Consultation Response from KC, Highways Development Management		
2020/90682 Croft Medical Centre, Cobcroft Road, Fartown, Huddersfield, HD2 2RU		
Discharge conditions 5 (ventilation) and 6 (boundary treatment) on previous permission 2014/90774 for erection of 2 storey medical centre with integral pharmacy and parking		
Date Responded:24/03/2020	Responding Officer: Mark Berry	Responding Ref:5-9SW/47

This application seeks approval to the discharge of conditions 5 and 6 on previous permission 2014/90774 for the erection of a 2 storey medical centre with integral pharmacy and parking at Cobcroft, Medical Centre, Cobcroft Road, Fartown, Huddersfield.

Drawing:
Site Plan
Boundary Treatment

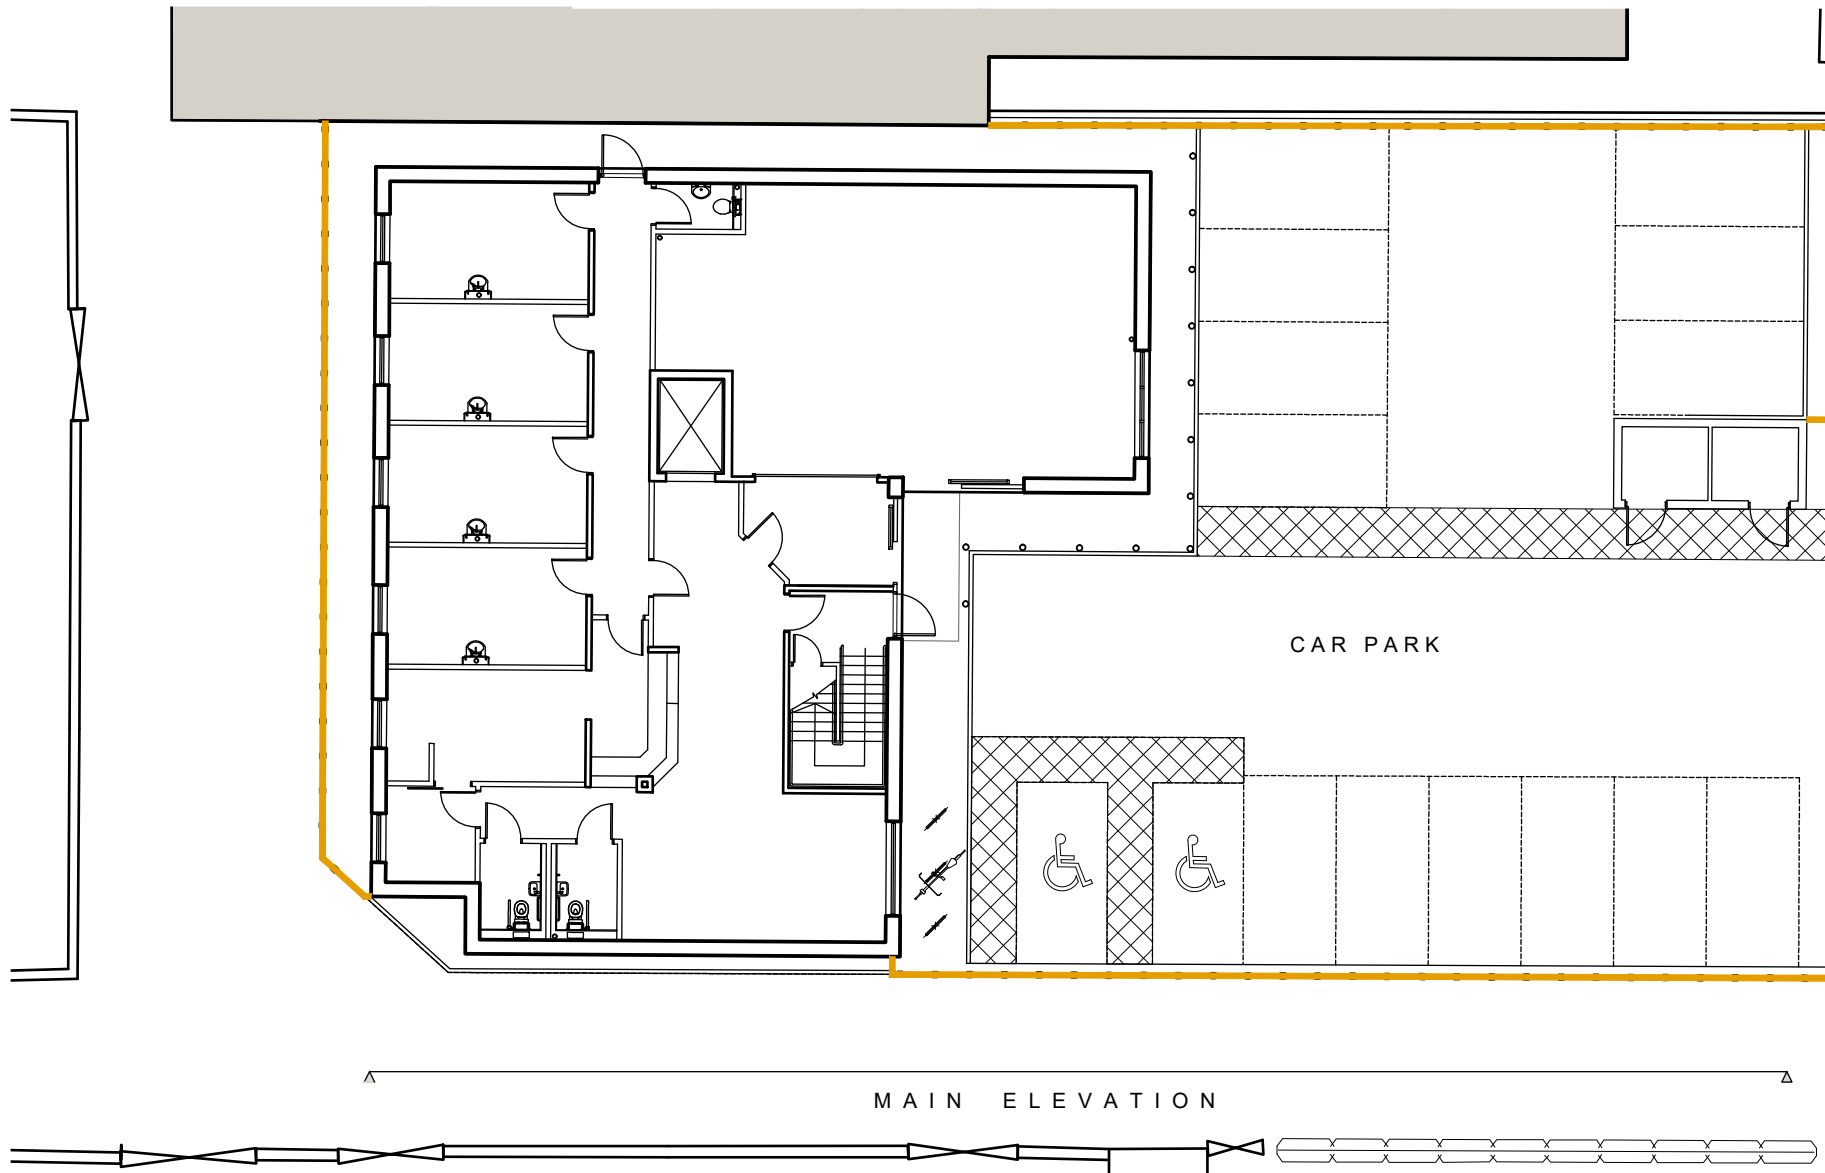
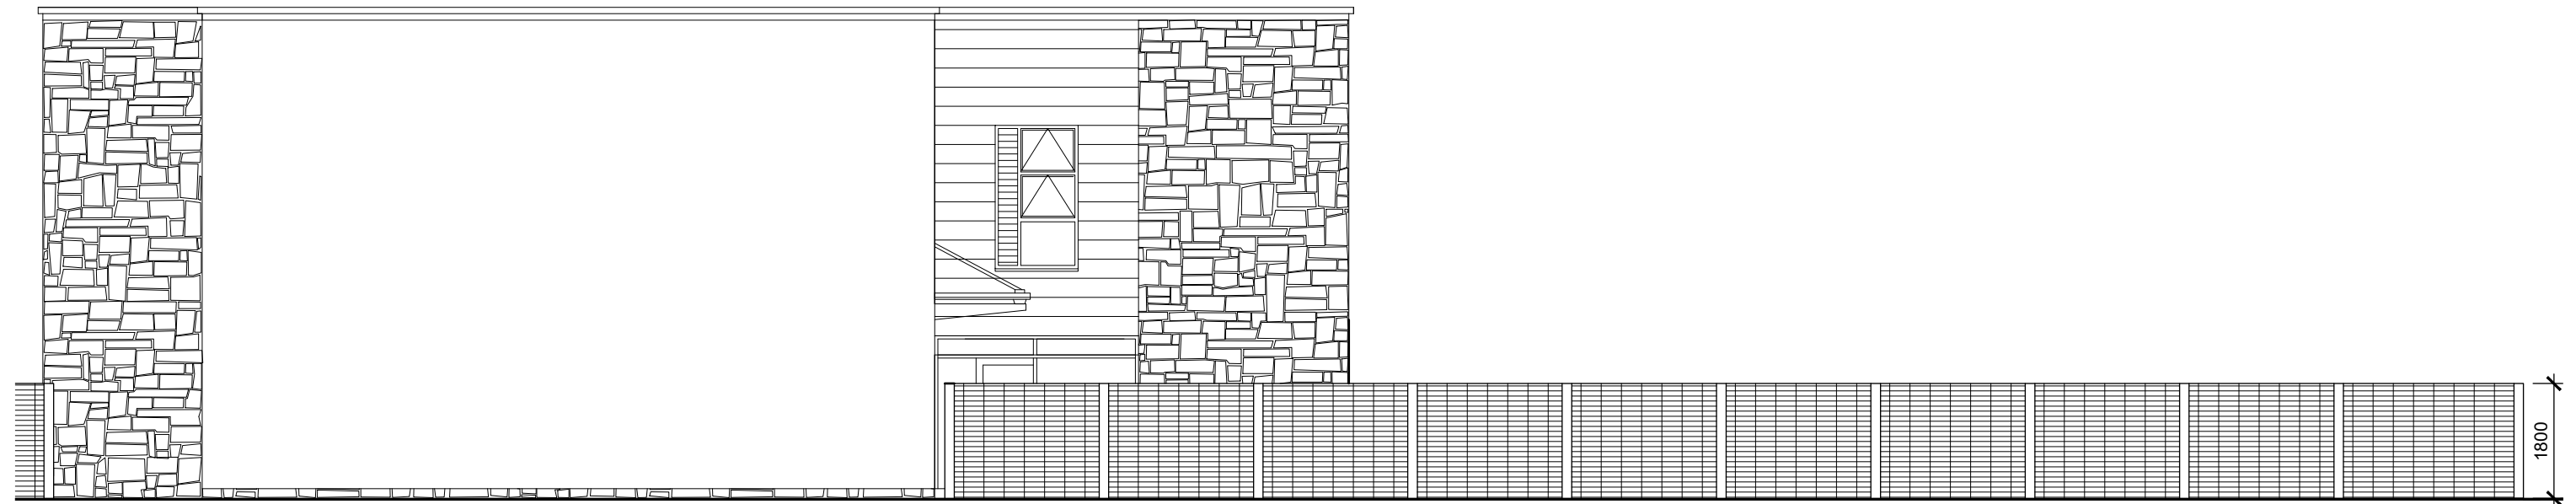
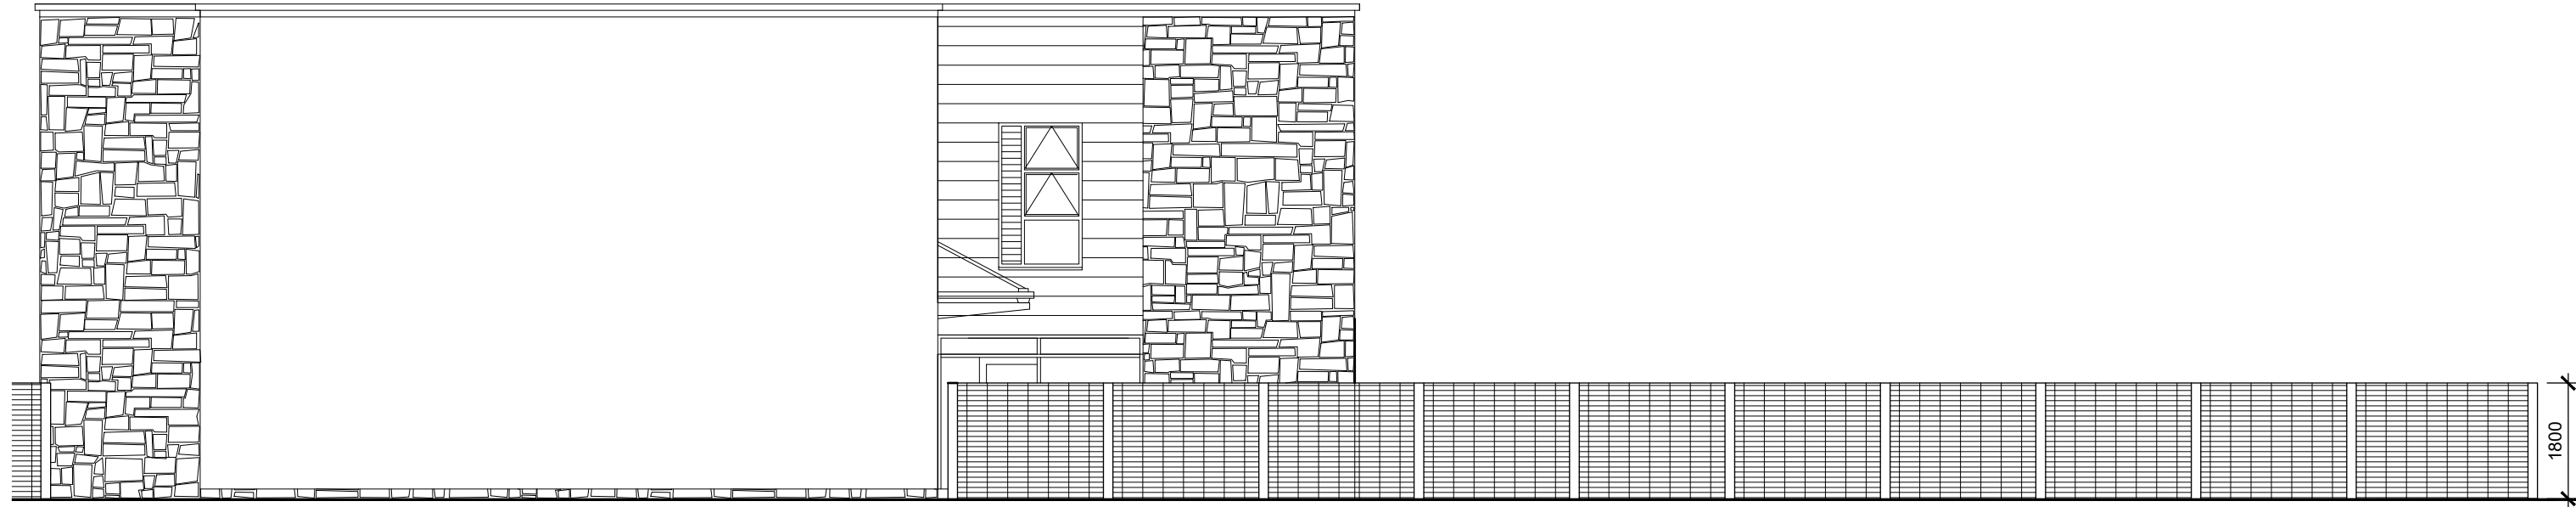
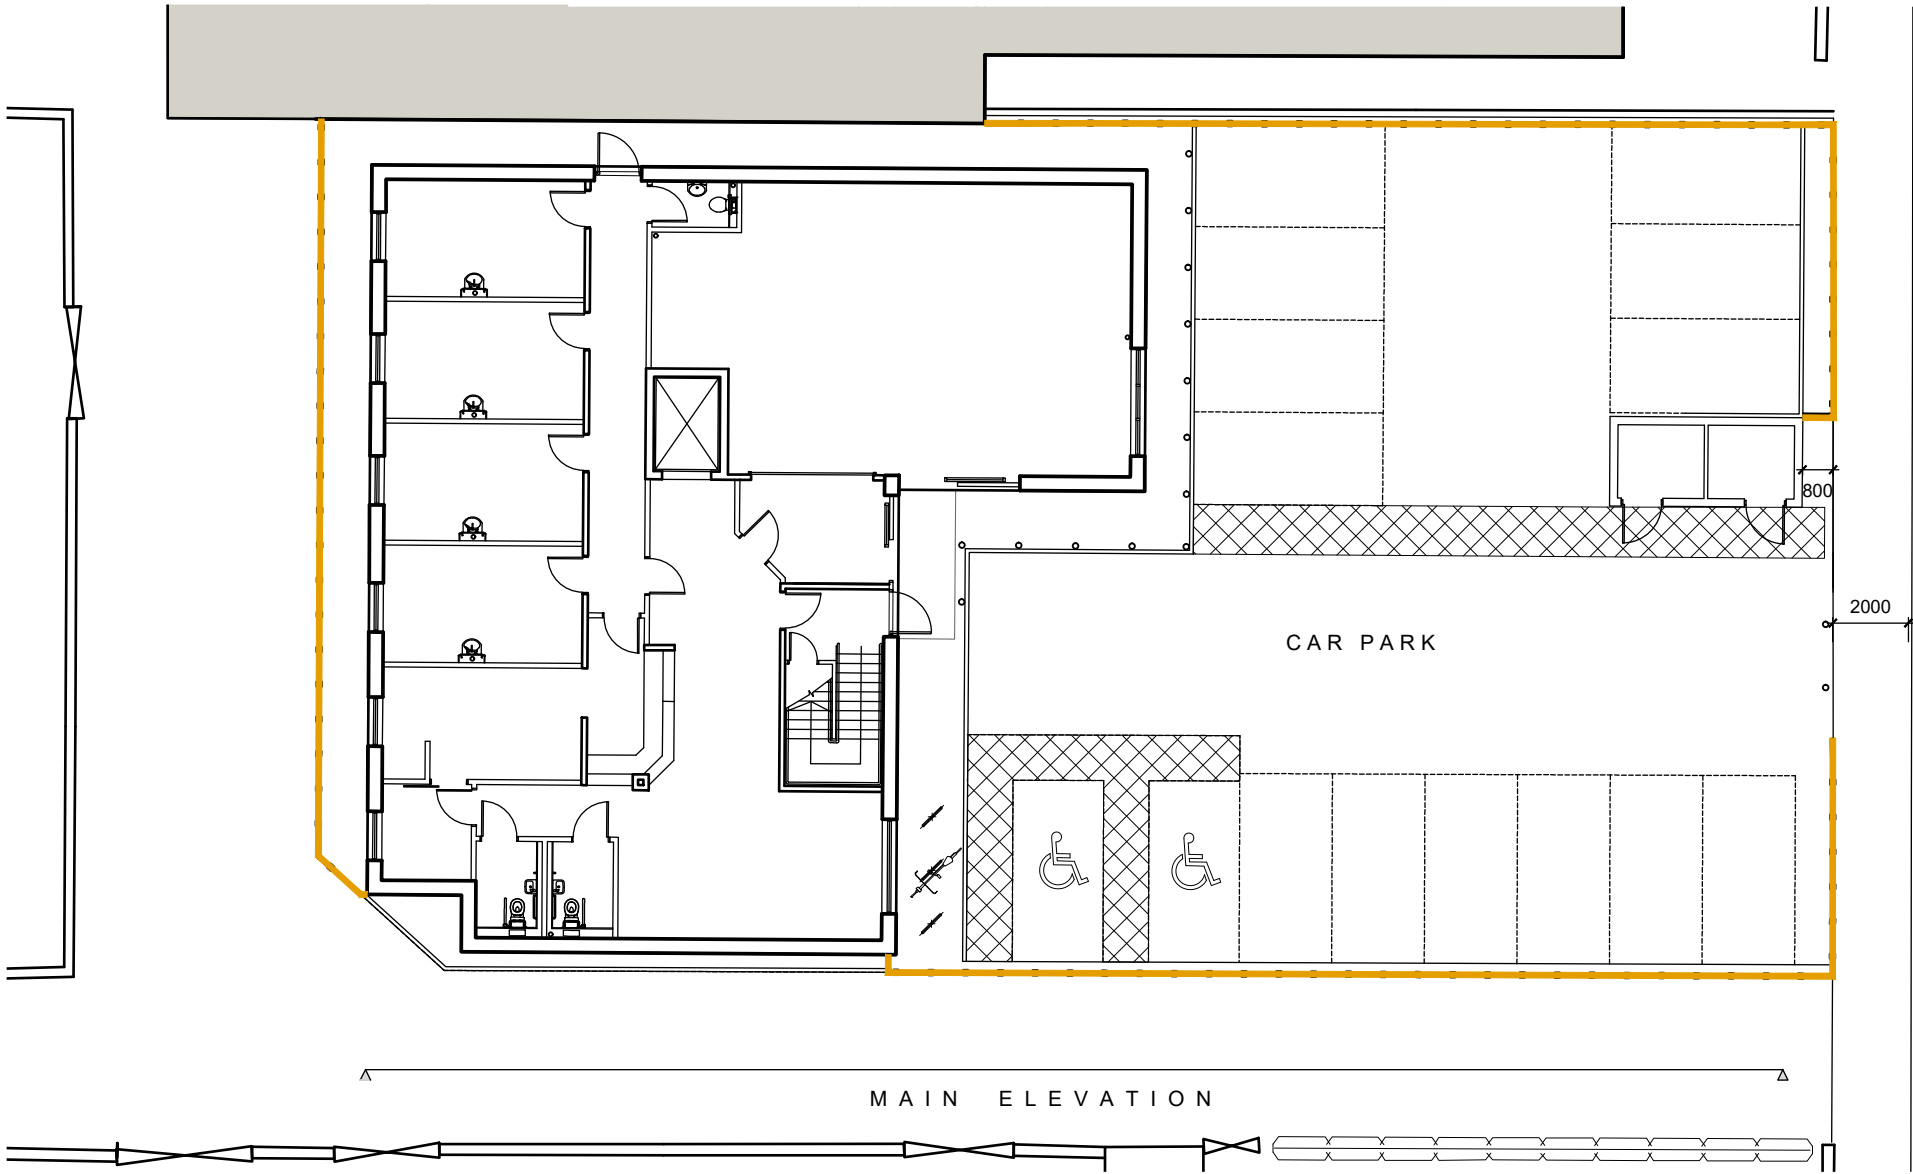
The proposals include the erection of a 1.8m high mesh fence along the frontage of the site.

In order to ensure that acceptable sight lines are provided from the site access onto Cobcroft Road, Highways Development Management would recommend that the fence is either reduced in height or set back 2.0m from the Cobcroft Road carriageway edge.
